# COLORADO GEOLOGICAL SURVEY

February 13, 2018

**Subject: Enclaves at Stonebridge PUD Development/ Preliminary Plan;  
File Number PUDSP183; El Paso County, CO; CGS Unique No. EP-18-0038**

Colorado Geological Survey has reviewed the subject referral. For this review we received: Letter of Intent (NES, 1.18), Grading and Erosion Control Plan (Tech Contractors, 12.17), Preliminary Plans (NES, 1.4.18), Subsurface Soil Investigation (Entech, 11.8.17), and various other documents.

TEST BORING LOCATION PLAN  
 WINDINGWALK FILINGS 1 AND 2, AND  
 STONEBRIDGE THE ENCLAVE FILINGS 4 AND 5  
 EL PASO COUNTY, CO.  
 FOR: TECH CONTRACTORS

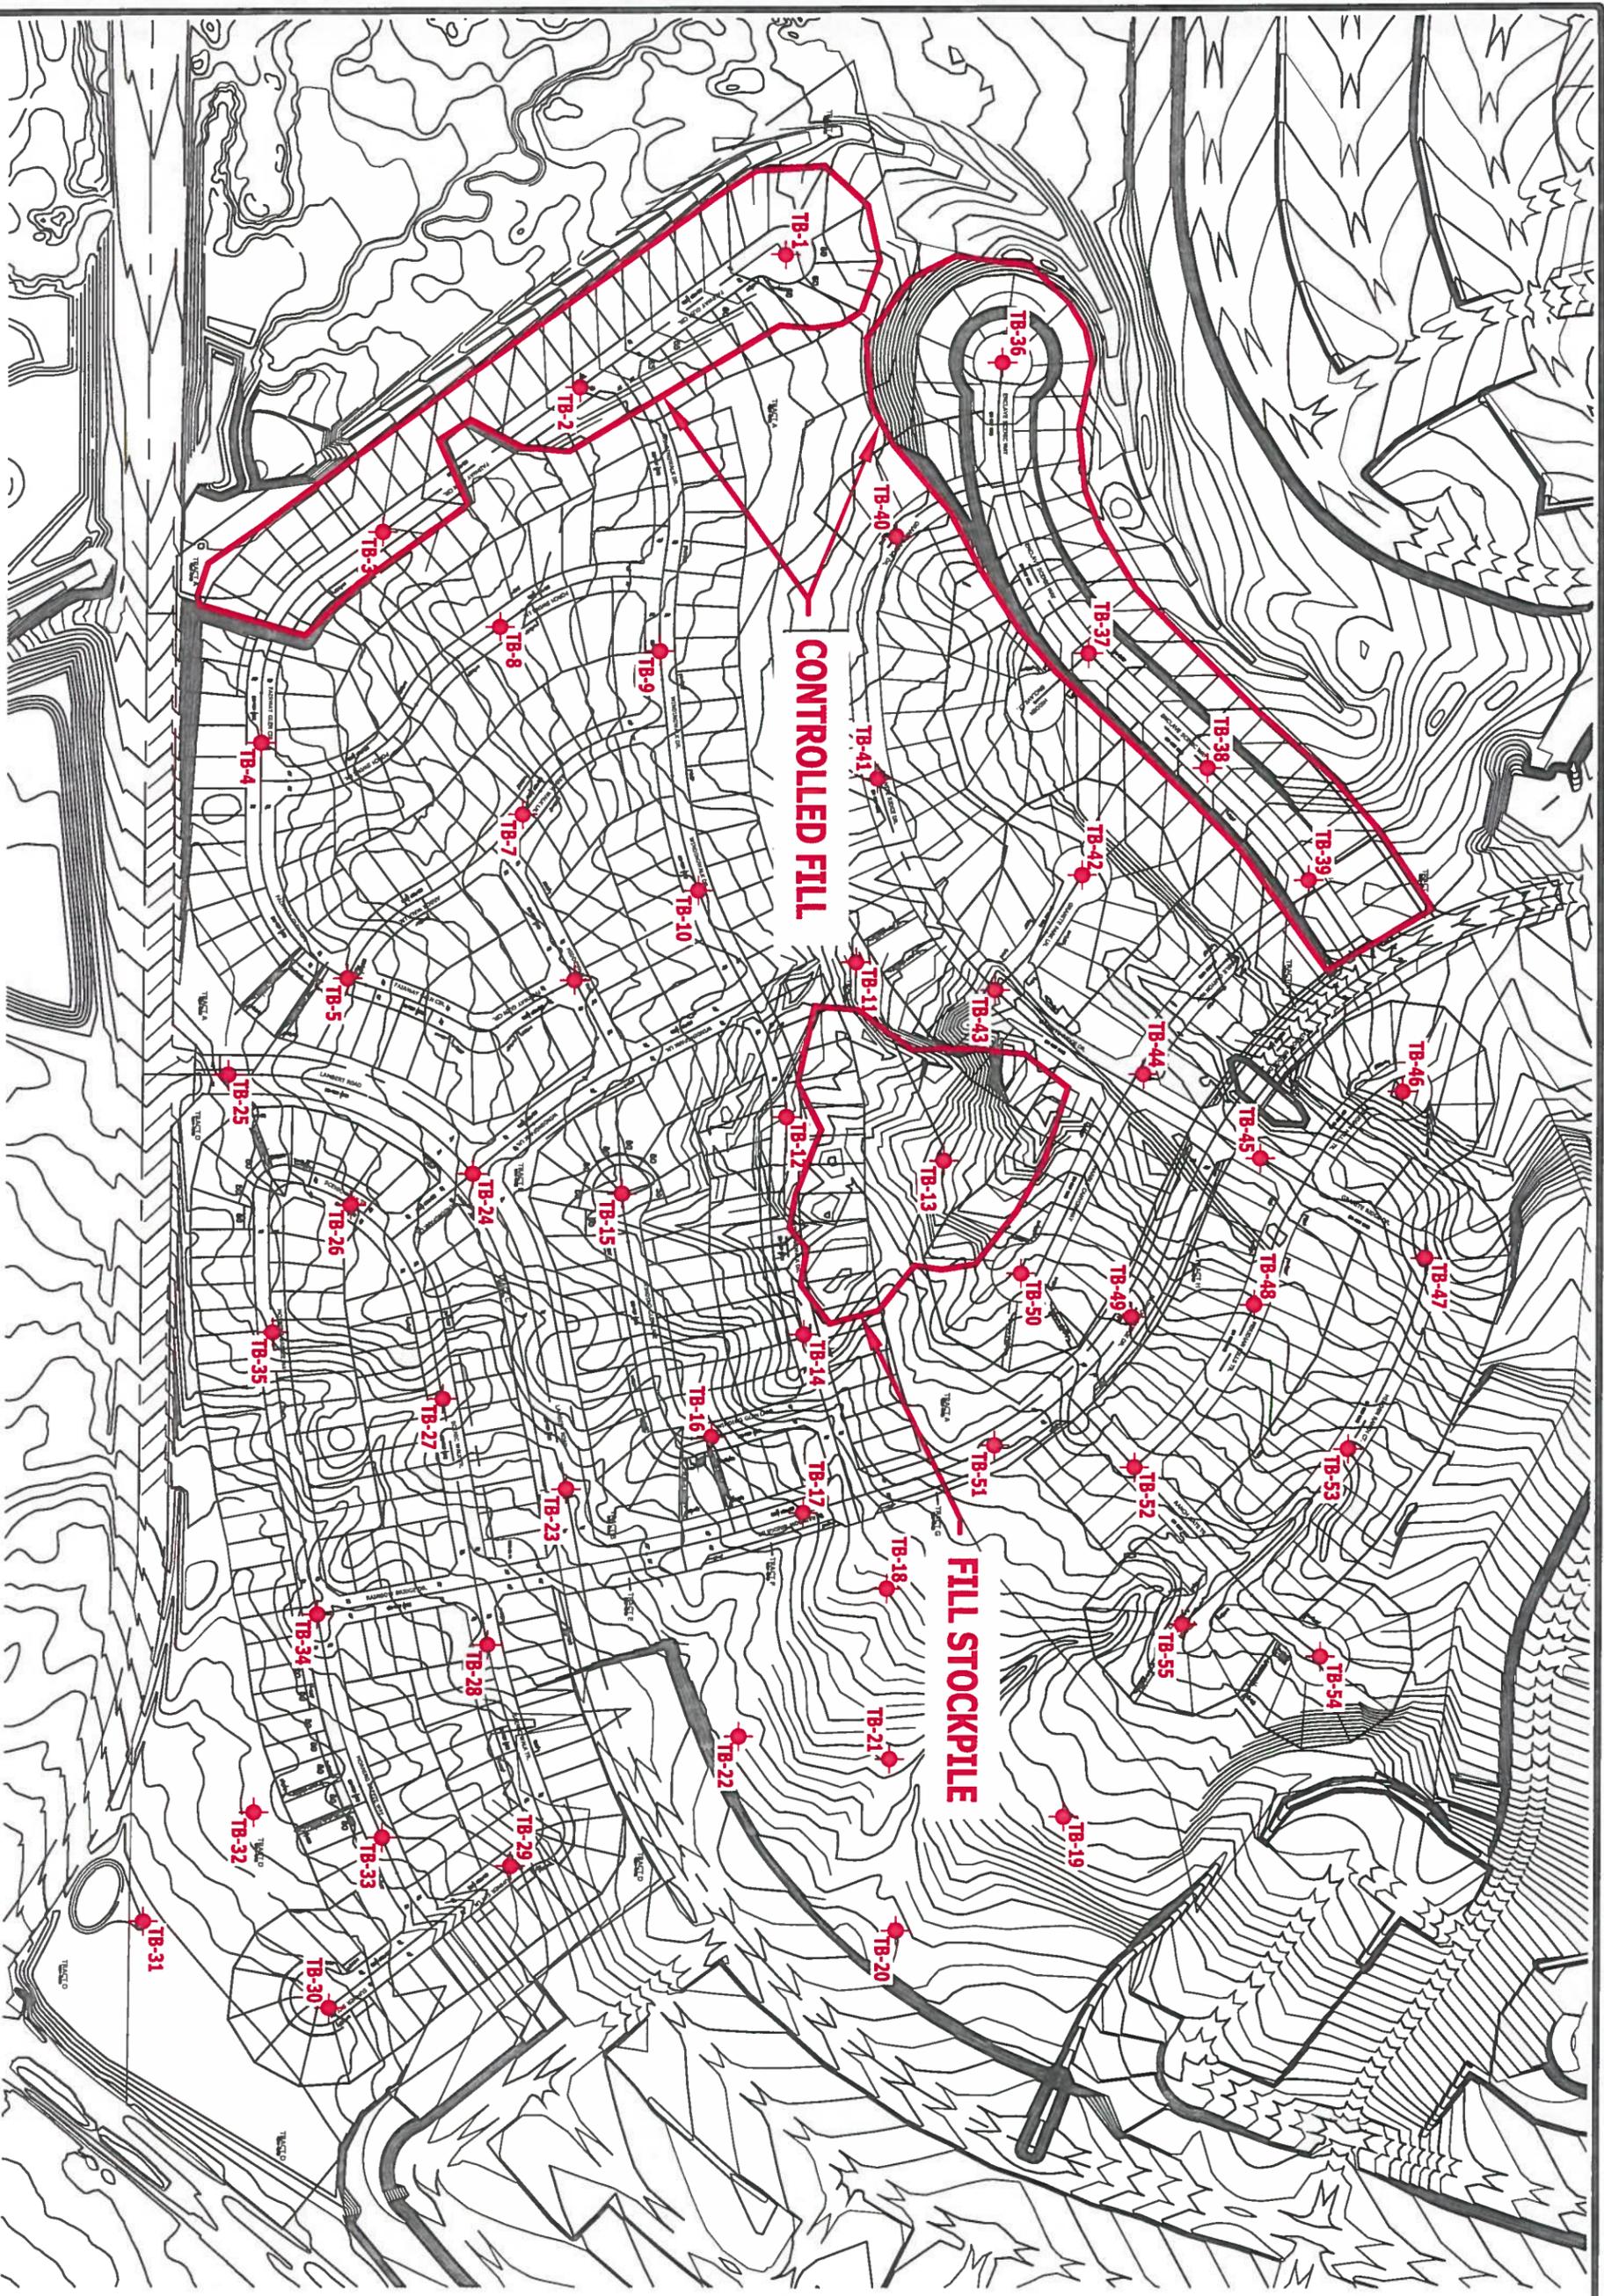
The subsurface investigation includes mapping of fill on the site. The site specific geologic report should include mapping of surficial geology including areas with loose and potentially collapsible soils and all other relevant surface geologic materials at this location. The mapping should also indicate locations of potential geologic hazards such as wind and water erosion, shallow groundwater and shallow bedrock. *The proposed lots should be overlaid on the geologic and geologic hazard maps prepared as part of the required geology and soils report.*

**Groundwater:** Shallow groundwater has been encountered in the subsurface investigation. Groundwater depths are reported from August, the time of drilling. Seasonal fluctuations of groundwater depth are normal and should be expected with higher groundwater levels typically occurring in spring and early summer. Monitoring of water levels through a full yearly season is necessary to estimate the range of water fluctuation and even that will not provide data on fluctuation during wetter and drier years. The Subsurface Soil Investigation states that "*Perimeter below grade foundation drain systems should be anticipated.*" It also states "*Temporary and permanent dewatering systems may be necessary at various foundation excavations.*" The requirement of perimeter below grade foundation drain systems and the potential for temporary and/or permanent dewatering systems for this development should be stated in the Plat and Development Plans. A maintained underdrain system may be required depending on final site grading and excavation and foundation plans.

Due to shallow groundwater basements may not be feasible in some locations.

- The applicant's geotechnical consultant should make lot-specific basement feasibility determinations based on a systematic groundwater level monitoring program consisting of monthly water level observations over at least on complete spring-summer-fall cycle, to determine maximum anticipated water levels across the site. Basements should be allowed only if these indicate that a *minimum* three foot (preferably five foot) separation distance between maximum seasonal water levels and lowermost floor and crawl space elevations can be maintained year-round.
